Jobe Developments Written Representation

we have a number of issues with regards to the new Horizon site entrance and the proximity to our site of 7 barn conversion

Scale	AS SHOWN	Sheet Size	A1	Sheet(s)	1 of 1
Drawing Number	WN0902-HZDCO-OHW-DRG-00063				Rev
				2.0

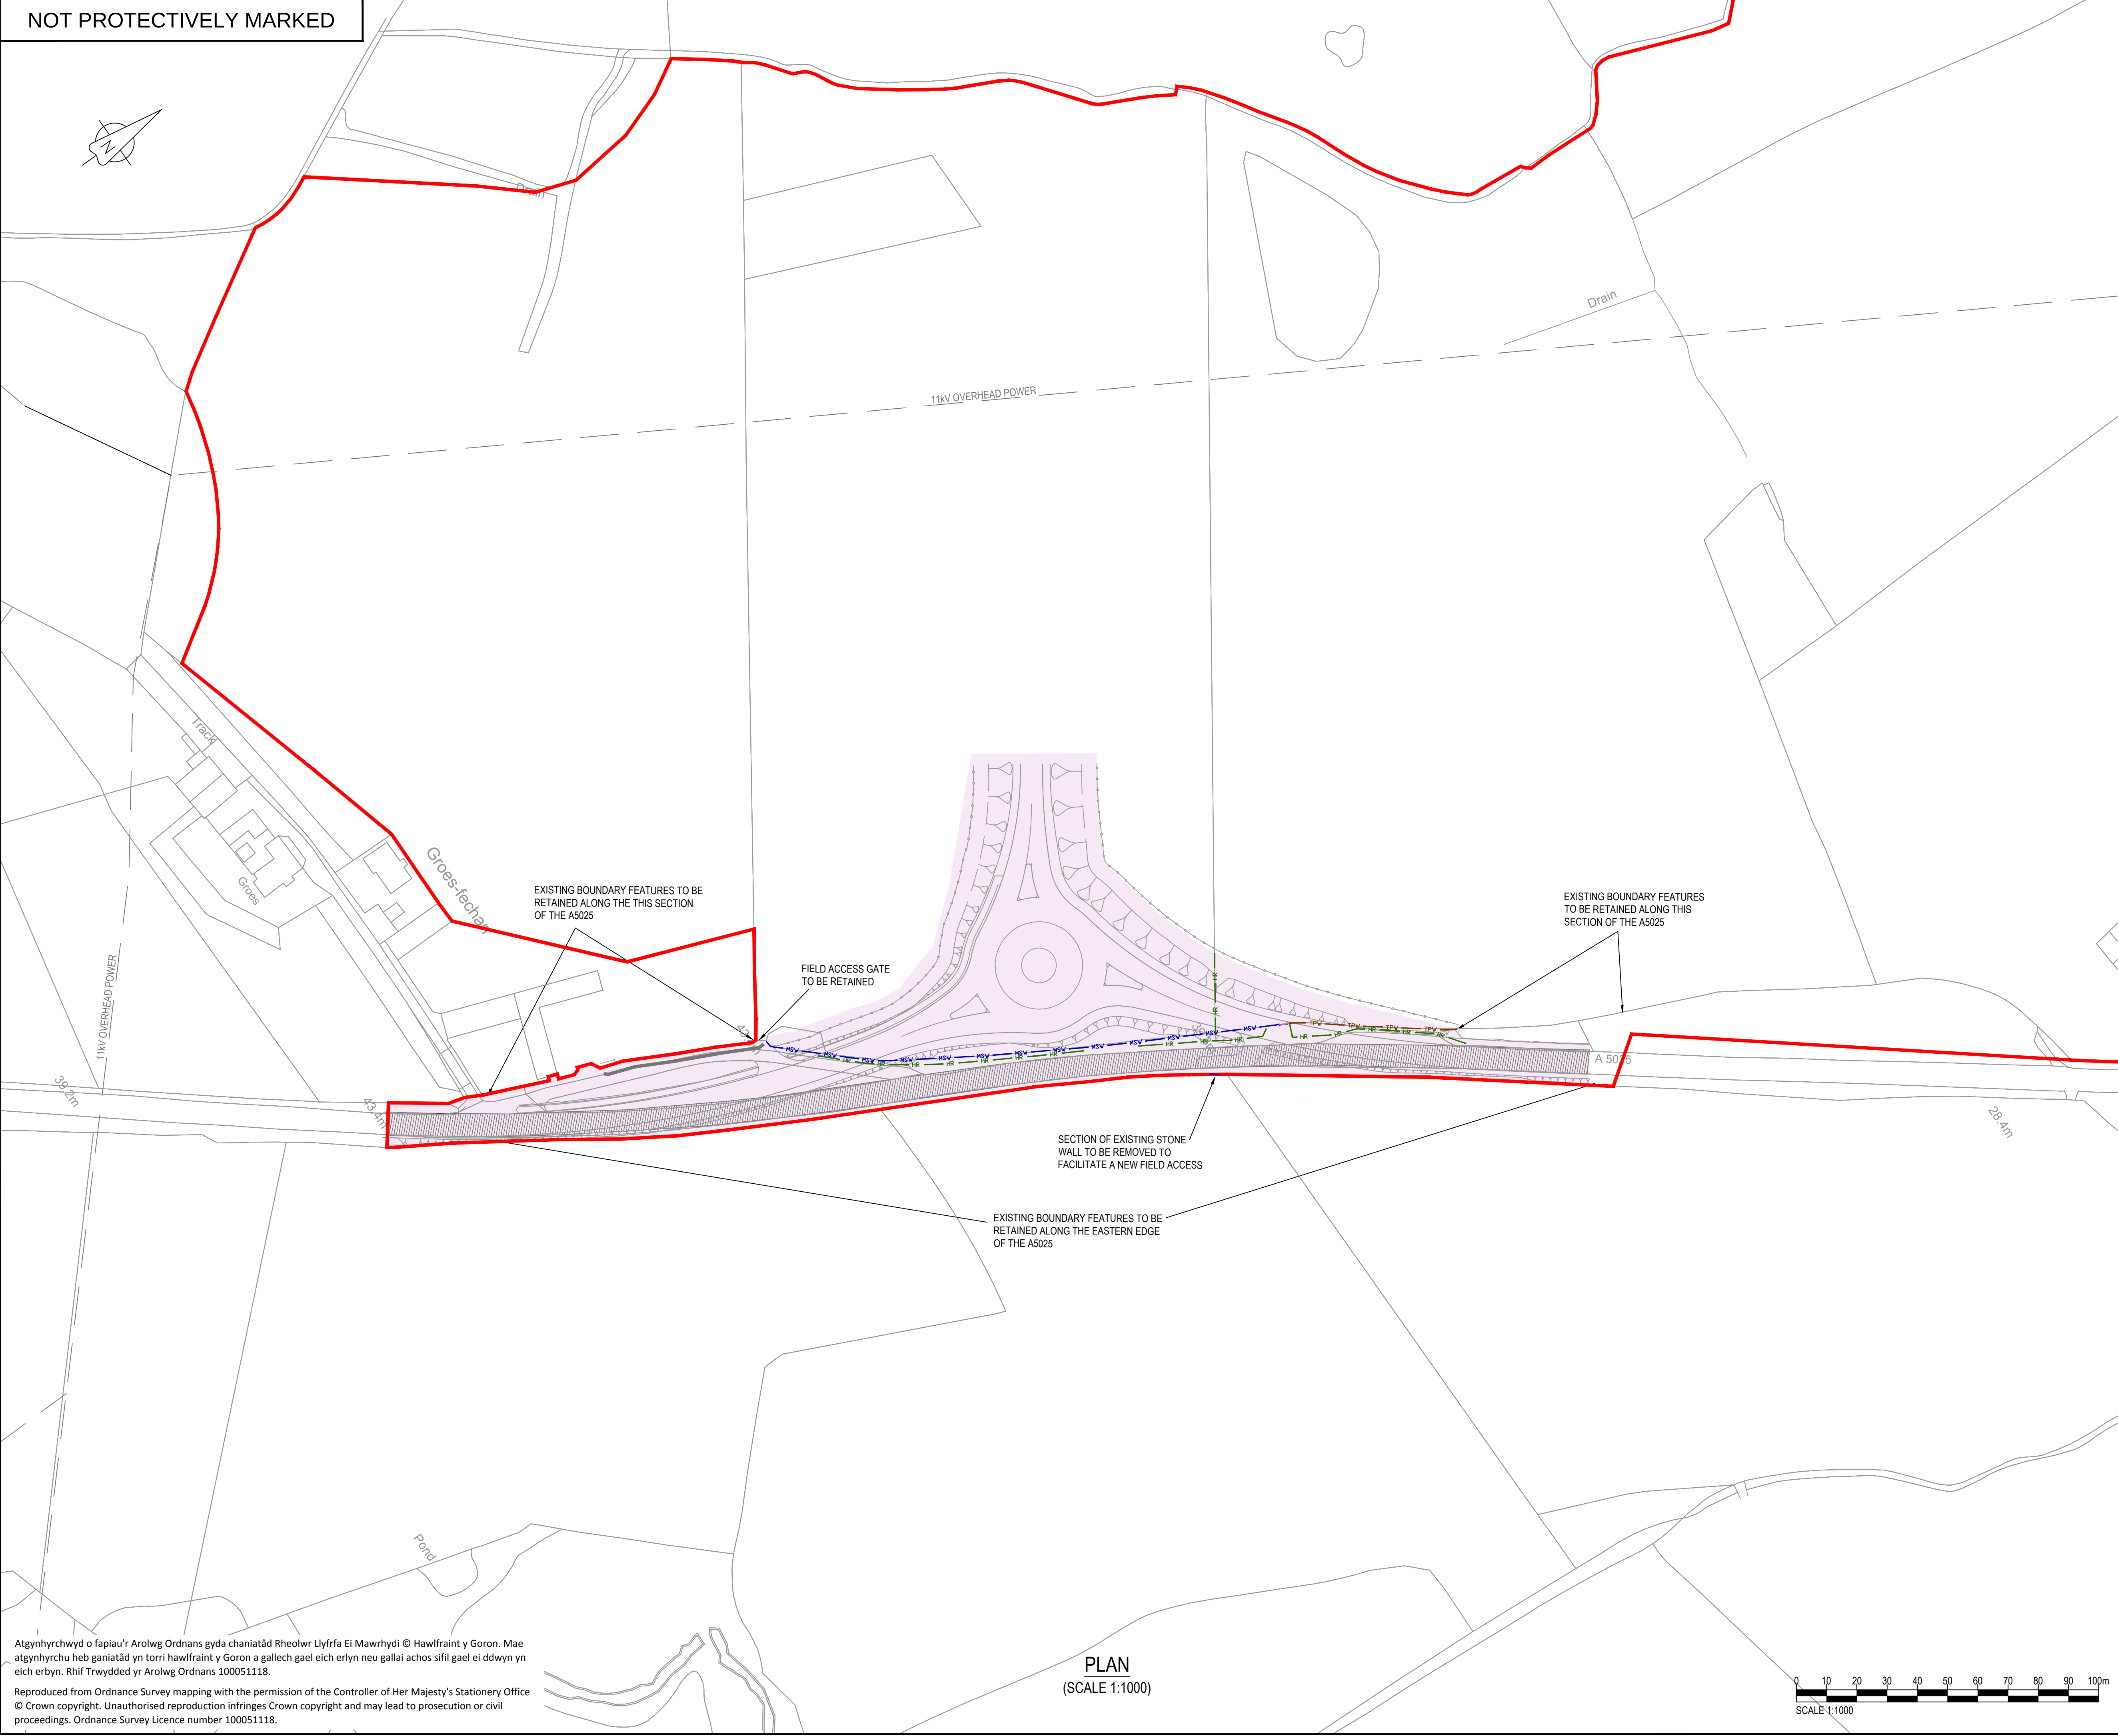
1. Section 8 roundabout is cutting across our access road which will compromise our entire site.

This access road is currently in a section 278 with the council and has been specifically designed for our access to our 7 barn conversions

Horizon will be undoing the section 278 work and our access will be compromised.

Please see Drawing number

WN0902-HZDCO-OHW-DRG-00063

Note: this drawing is dated May 2018

3. ***Our surface water for our entire site is beneath there new road layout - this has not been considered by Horizon as they had no idea this was approved by Anglesey county council in 2011 this would also compromise our entire site.***

4. ***The new costal path has been drawn on our land at the rear of our site and not on land controlled by horizon, please cross reference drawing no:
WN0902-HZDCO-OHW-DRG-00063 with our land registry number: WA873267
And it must be noted that the layby is subject to a section 278 with Anglesey count council, this is a legal document and Horizon intend to ignore it***
